Prelim Plan V_4.pdf Markup Summary

Subject: Text Box
Page Index: 2
Date: 3/26/2019 2:11:10 PM
Author: dsdrice
Color: ■
Layer:
Space:
Page Label: [1] Plan

1  
C  
OVERALL PRELIMINARY PLAN

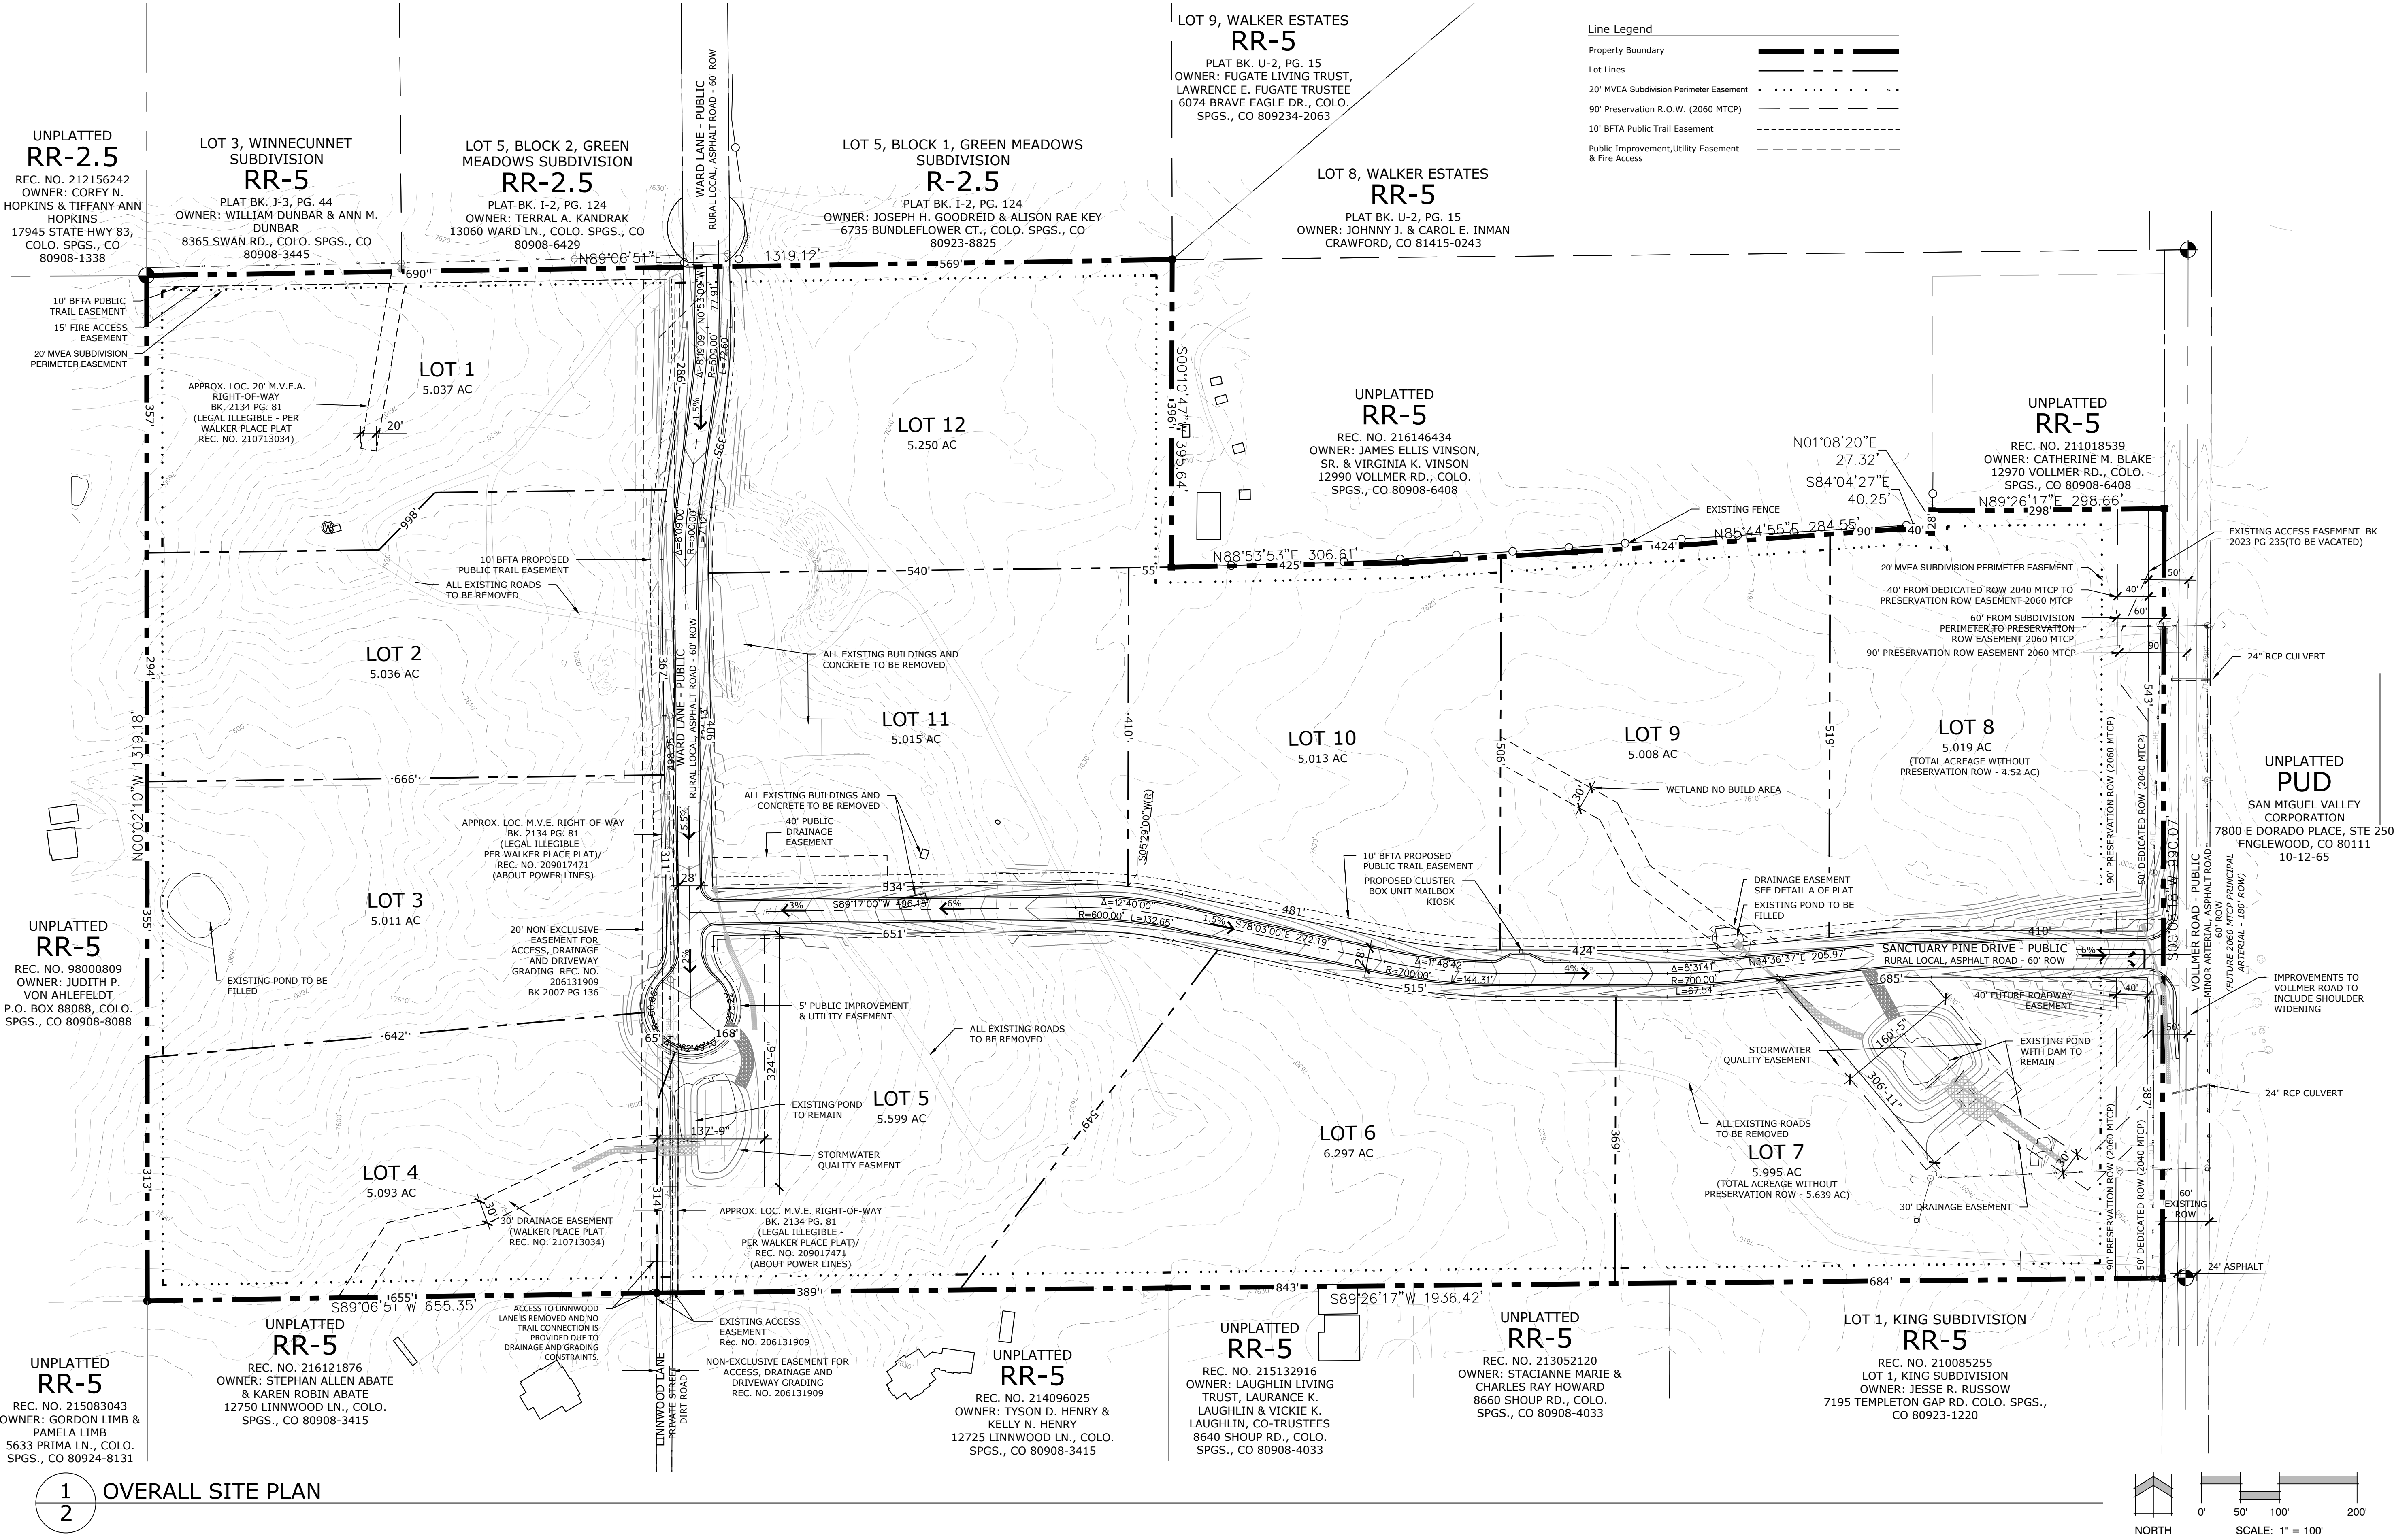
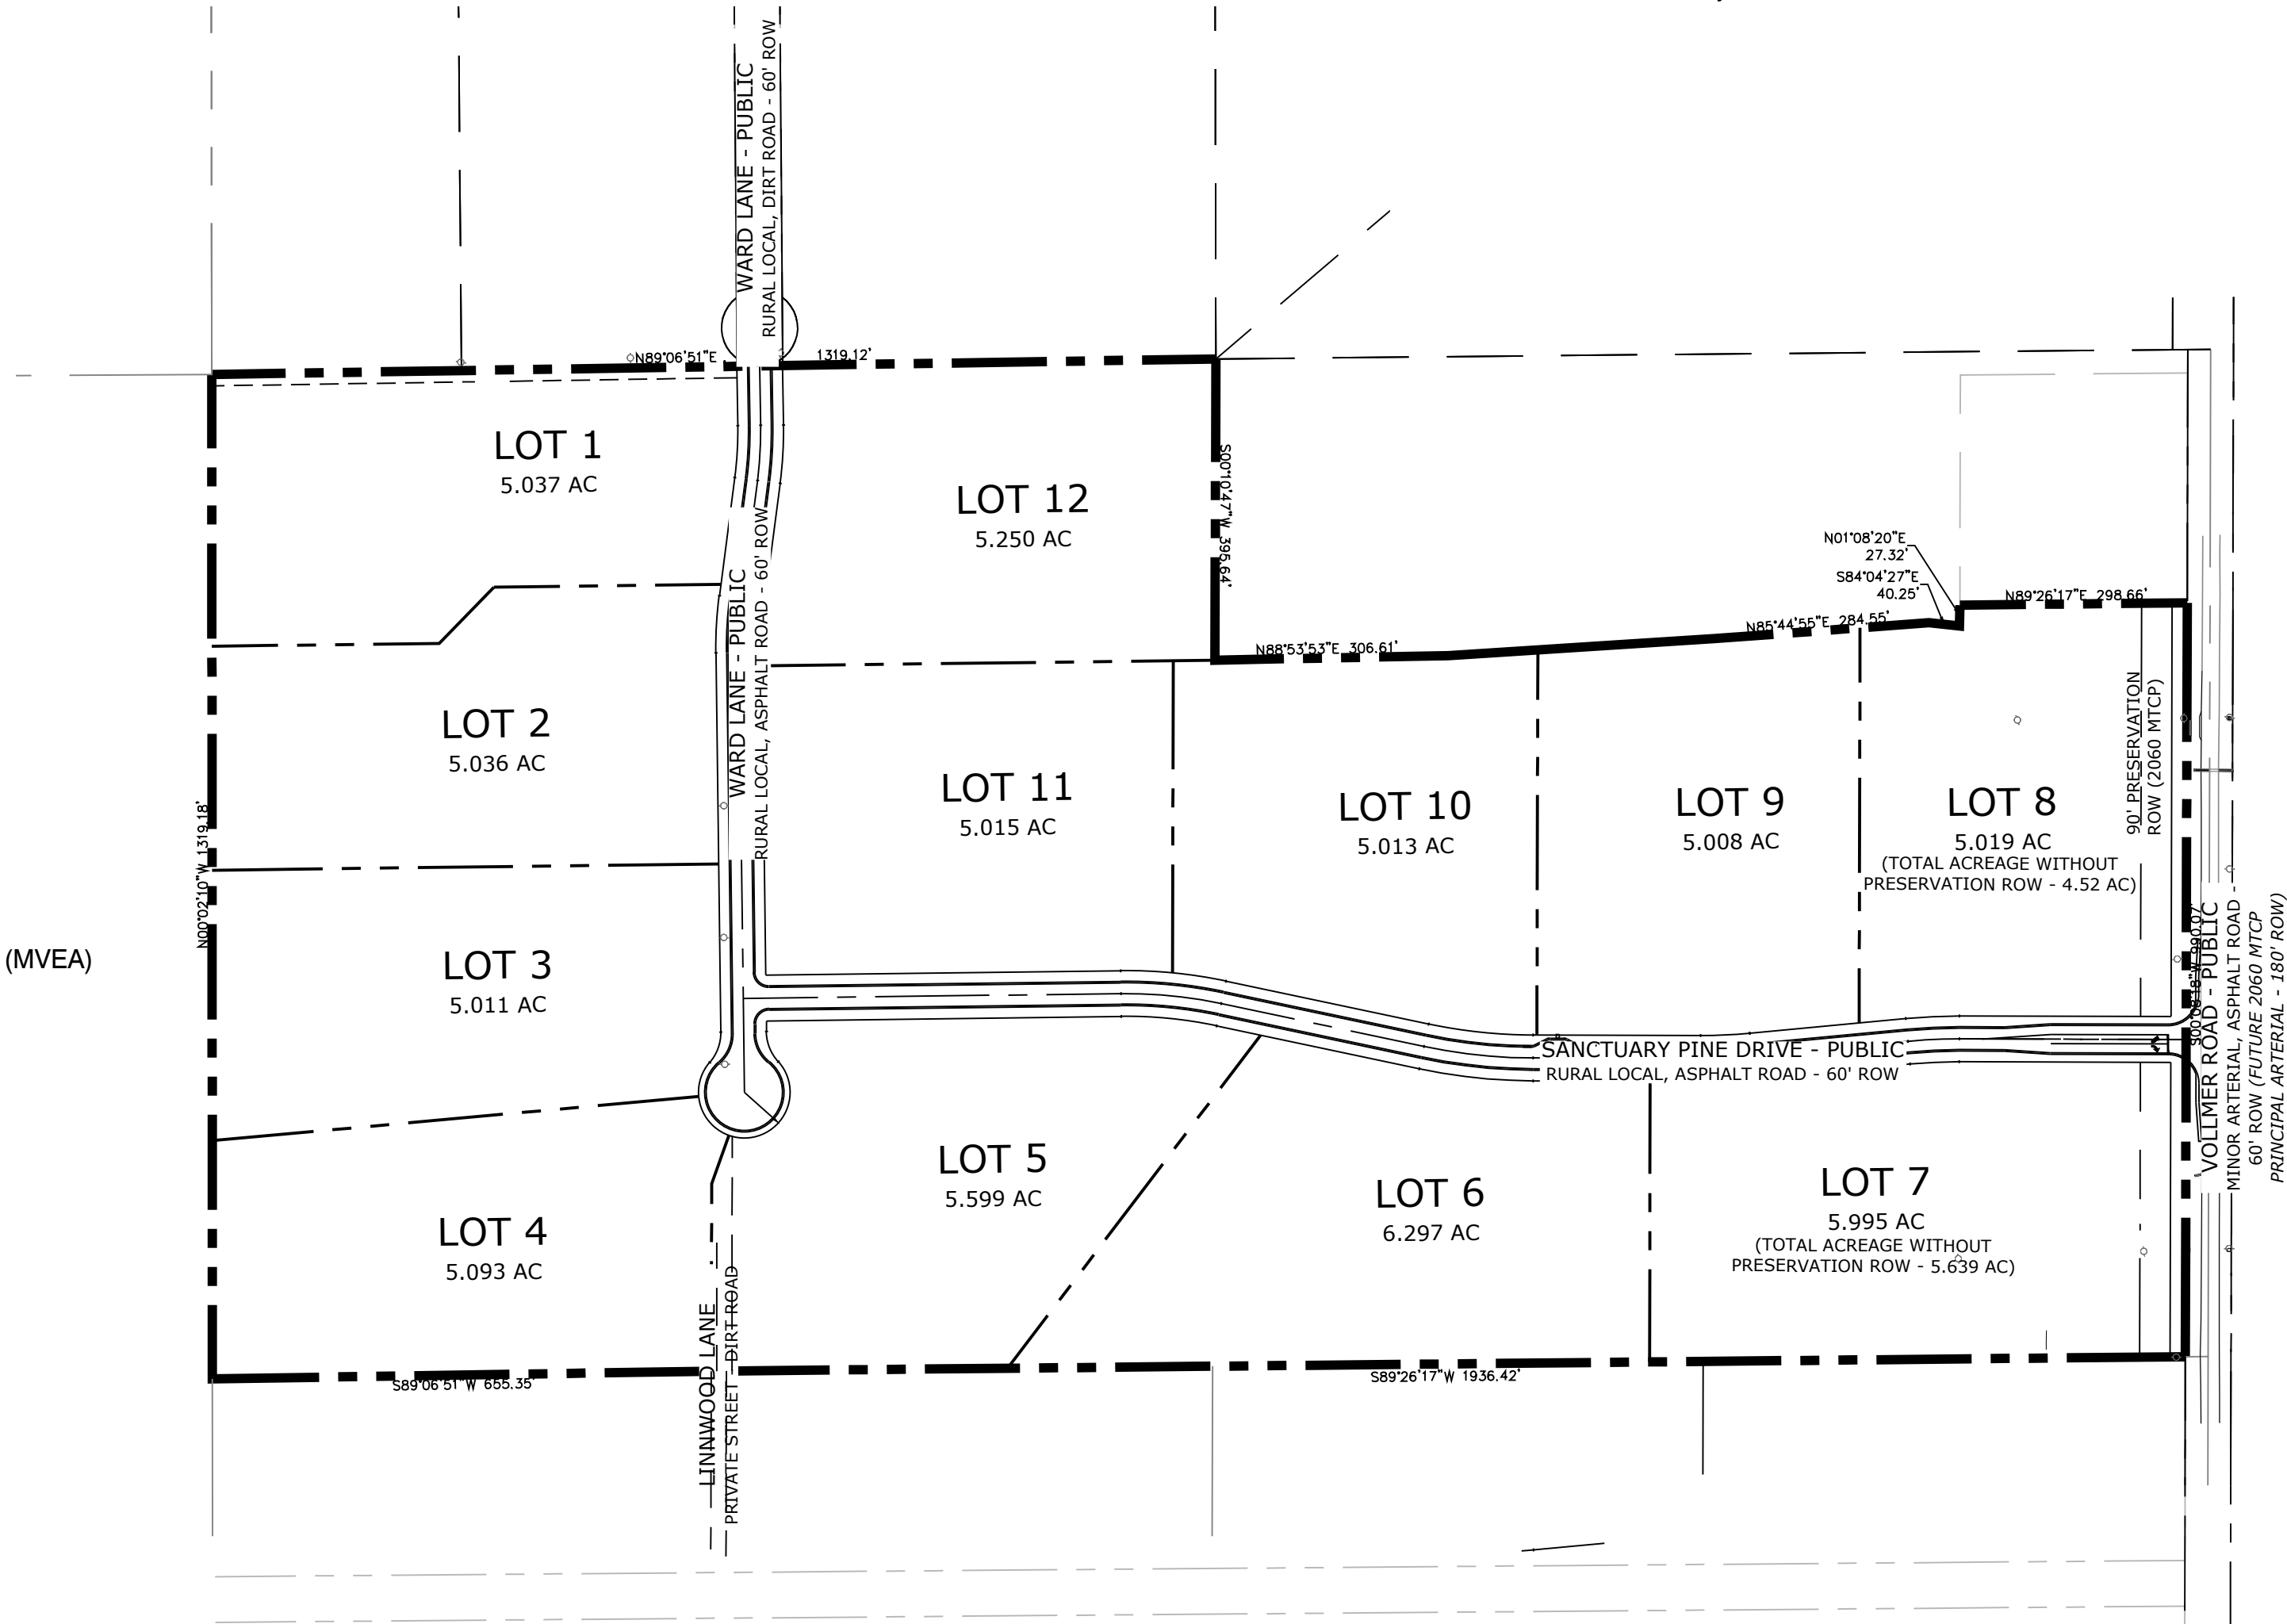
Label approximate road grades. (Unresolved from comment letter.)

Verify

Verify

Labels added.

Revised to 24"

Revised to 24"
